Please ask for: Mrs D Johnson
Email: daun.johnson@arun.gov.uk
Telephone: 01903 737762
Our Ref: FP/248/20/PL
Your Ref:
Date: 8th January 2021

Application for Planning Permission

Development: Revised details relevant to the sport pitch & changing facilities building (previously approved under Y/38/09/). This site also lies within the parish of Yapton & is in CIL Zone 4 (Zero Rated) as other development.

Location: Land North Of Felpham

PRELIMINARY		Redesign		HJS
REV. No.	DATE	DESCRIPTION	INITIALS	
A	17/12/20	Redesign	HJS	
Client				
 BARRATT				
Project Felpham Changing Facilities, Bognor Regis				
Title Engineering Layout				
Scale 1:250 @ A0		Date Jan 16	Drawing No. 5292:01	Rev A
Checked		Drawn HJS

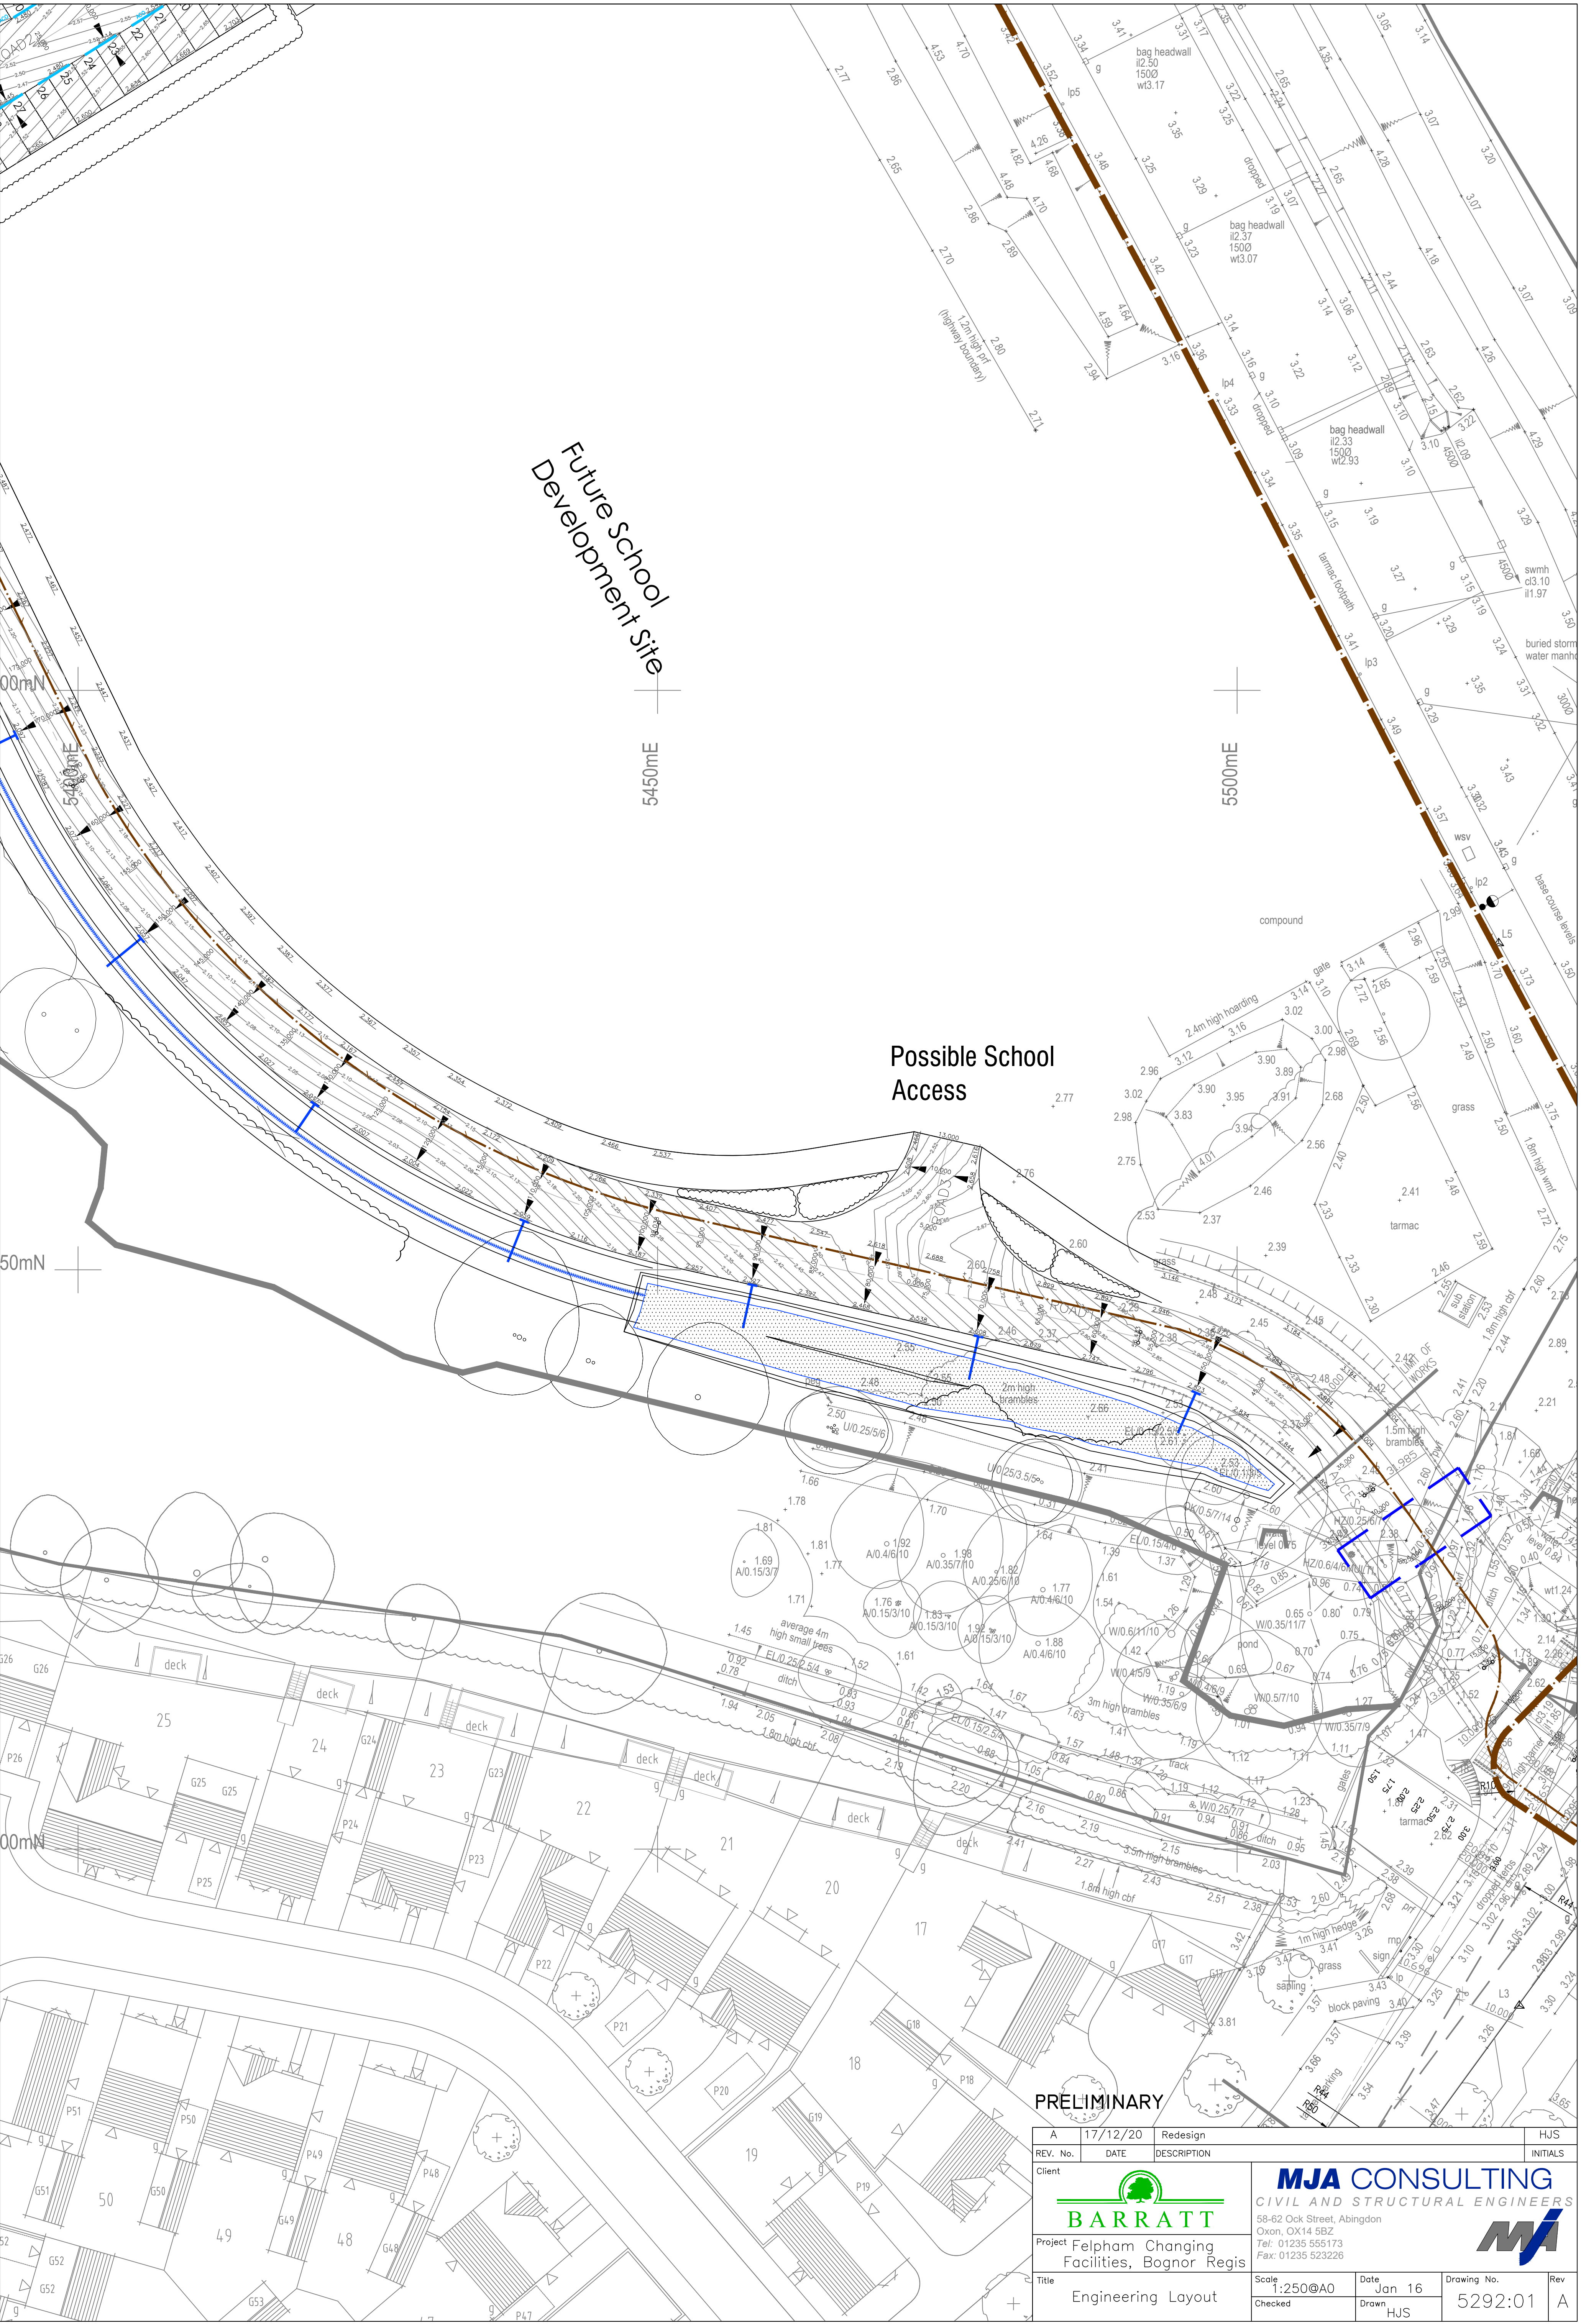
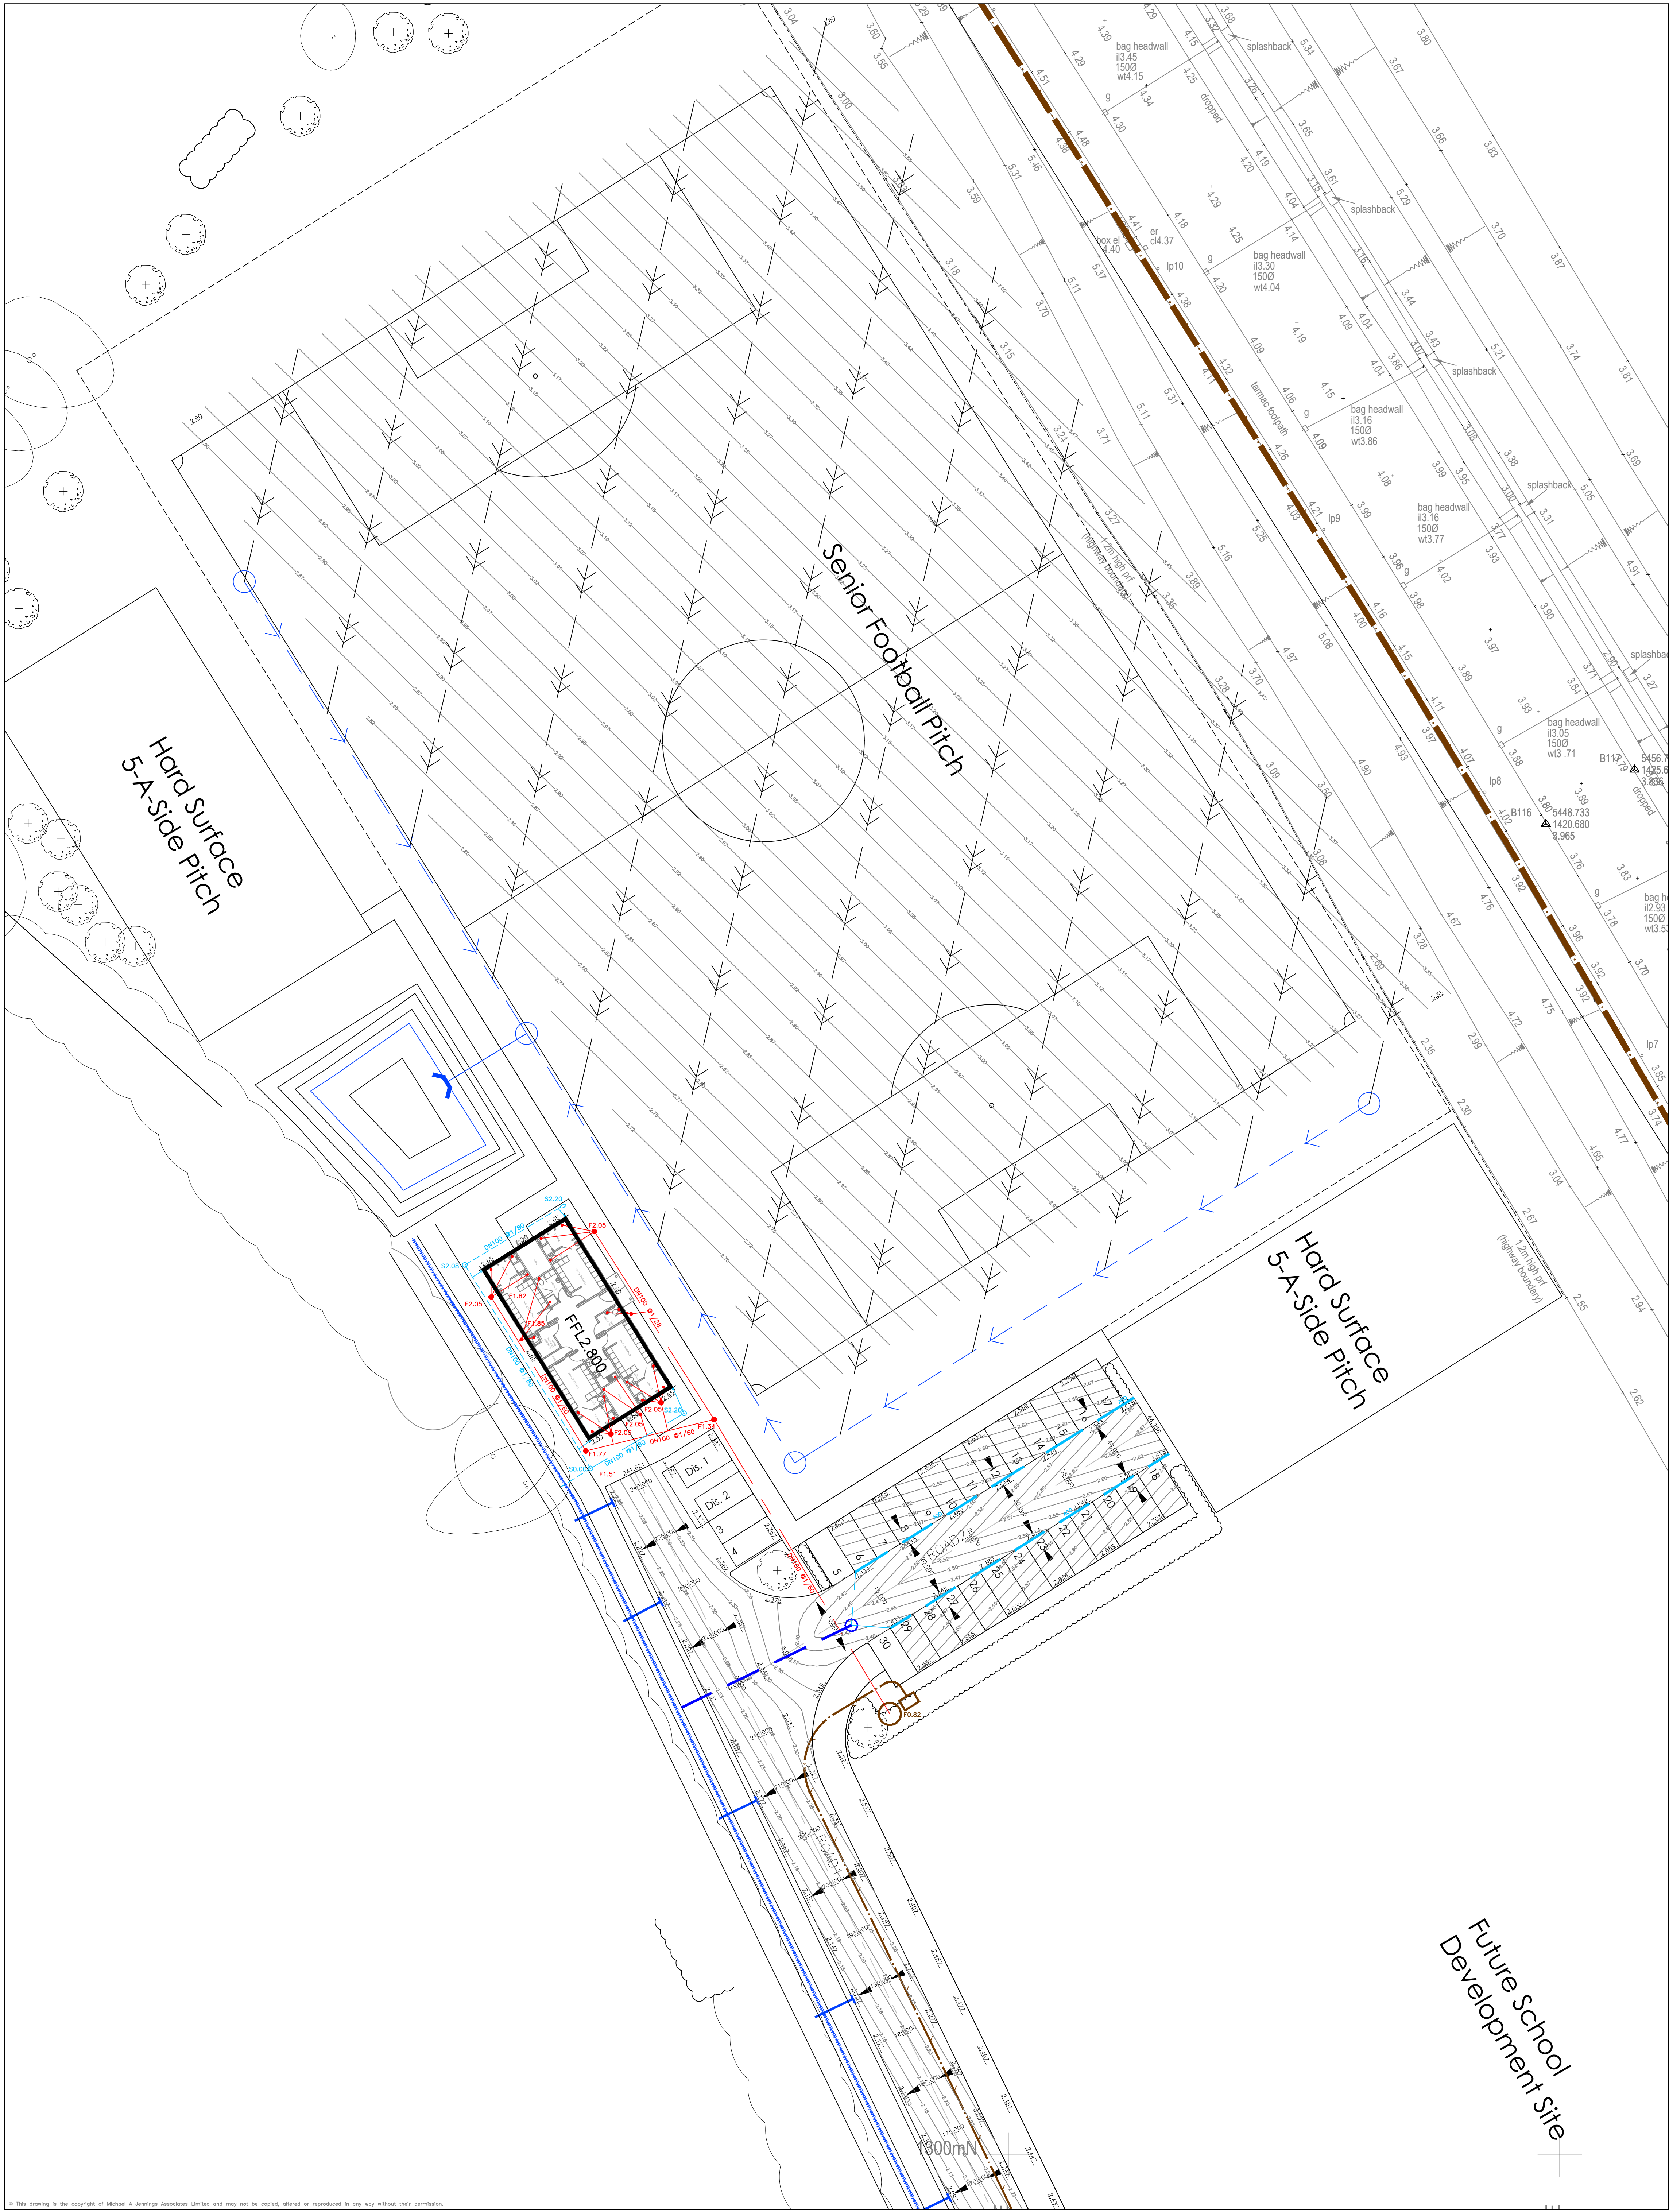
Block Plan

Please show the position of the charging points.

Drawing Title:
CHANGING FACILITIES BUILDING
LOCATION PLAN

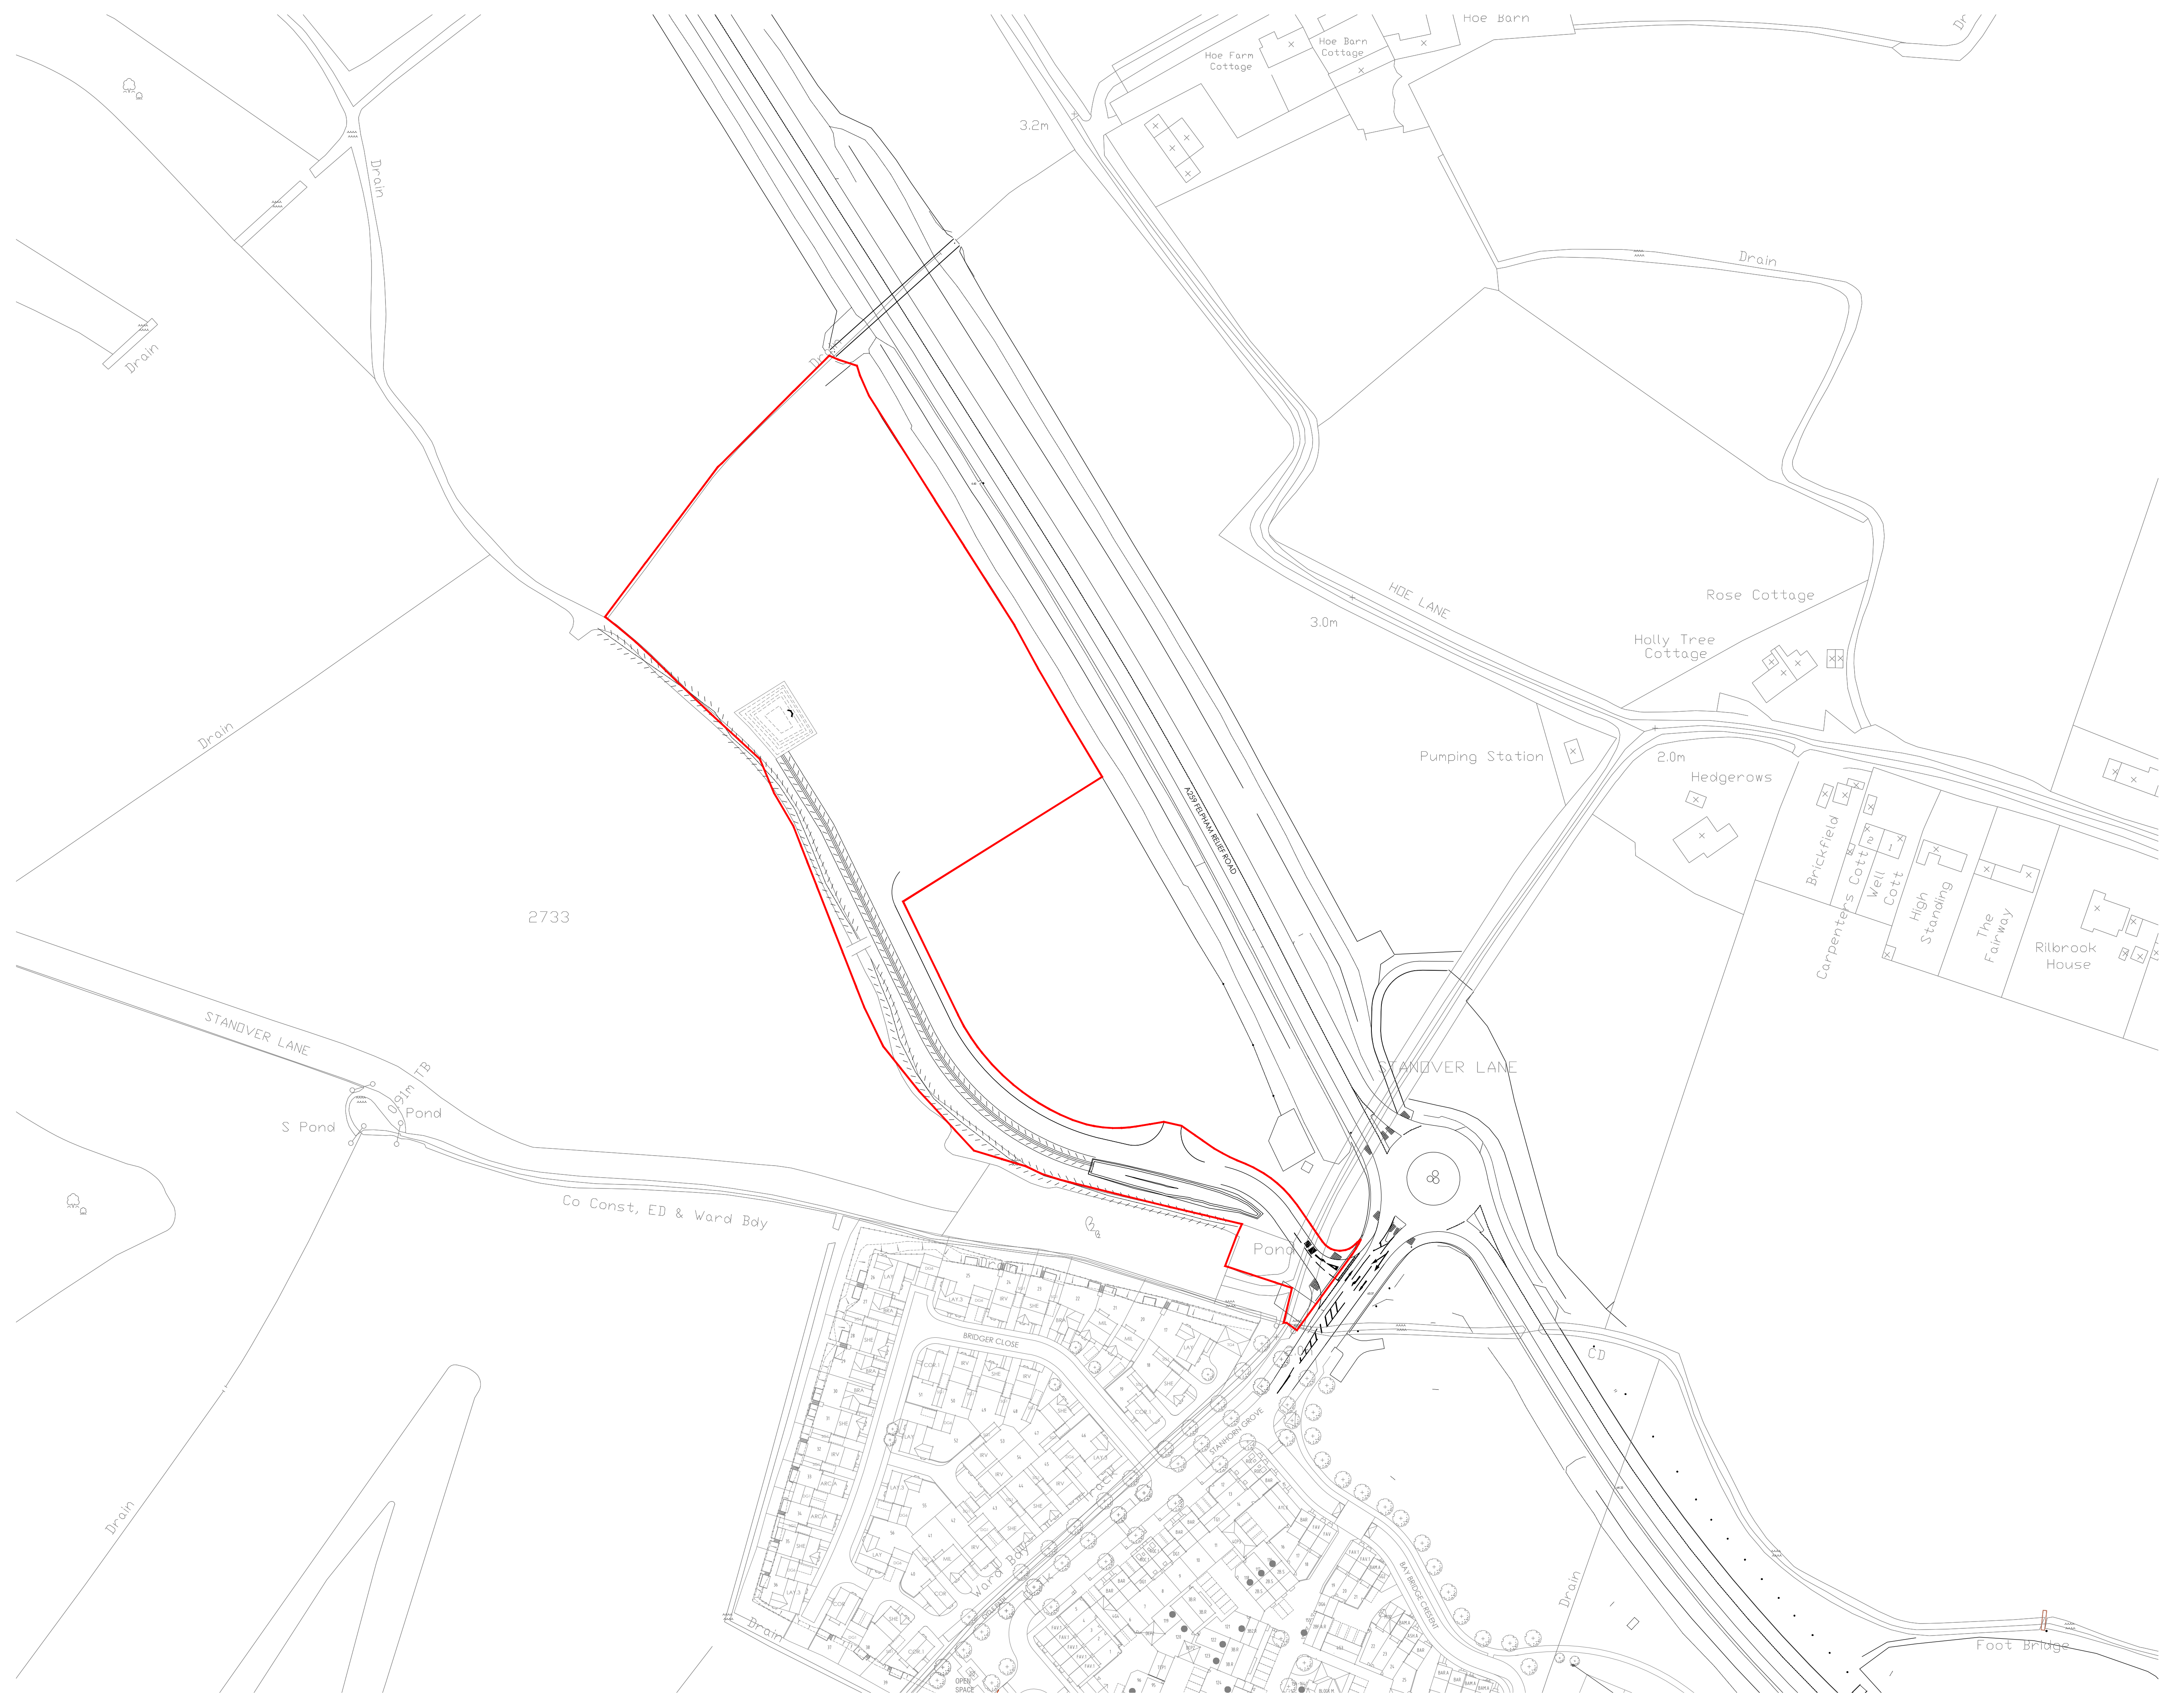
Location Plan

Please provide a North point.
